SUBJECT: Engineering Review Comment  
Mountain View Electric Association Inc. (MVEA)

**Project Name: Preamble at Hannah Ridge Filing 3 – Final Plat**

**Project Number: SF251**

**Description:** A proposed development of 38 residential lots and 4 tracts located west of Marksheffel Rd. and north of Constitution Ave. in Township 13S, Range 65W, Section 32.

THIS DOCUMENT HAS NOT BEEN  
PLAT CHECKED

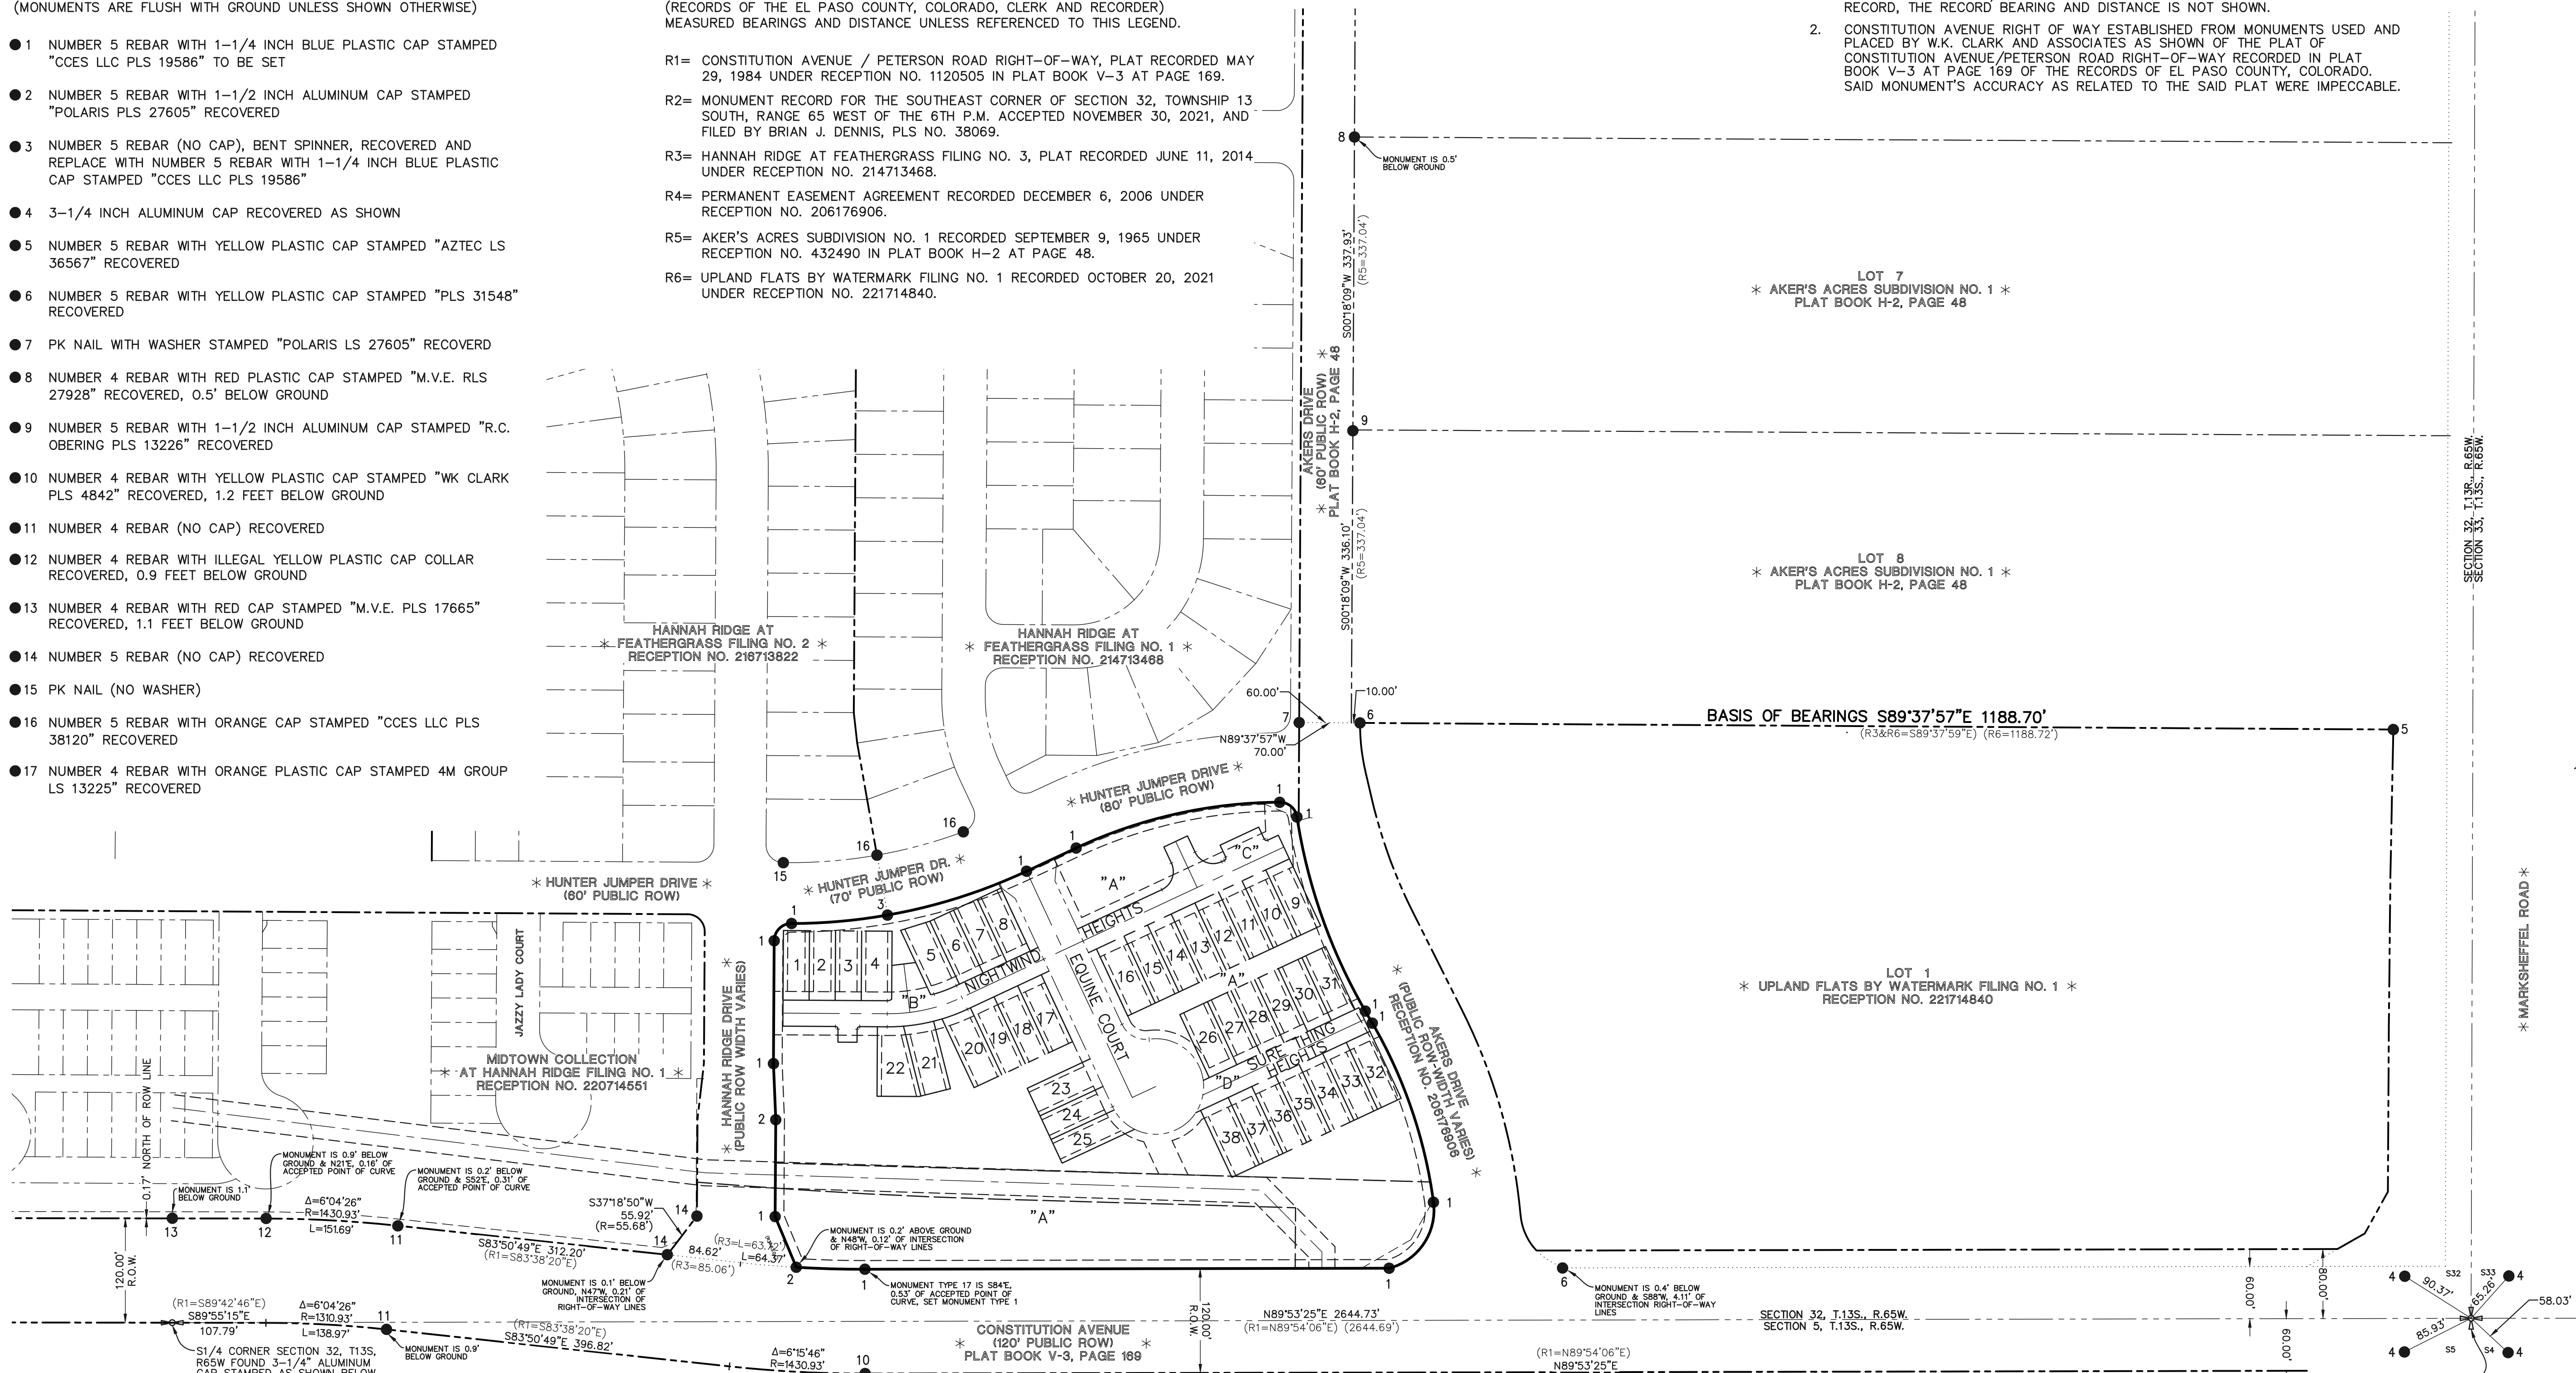
MVEA requests a ten (10) foot front lot line utility easement, all open spaces and tracts will be defined as a public utility easement, and a twenty (20) foot exterior boundary utility easement on the plat and all tracts. MVEA will work with the developer on the electric line design. MVEA also requests the platting of MVEA's existing facilities with easements on the plat. Additional easements may be required.
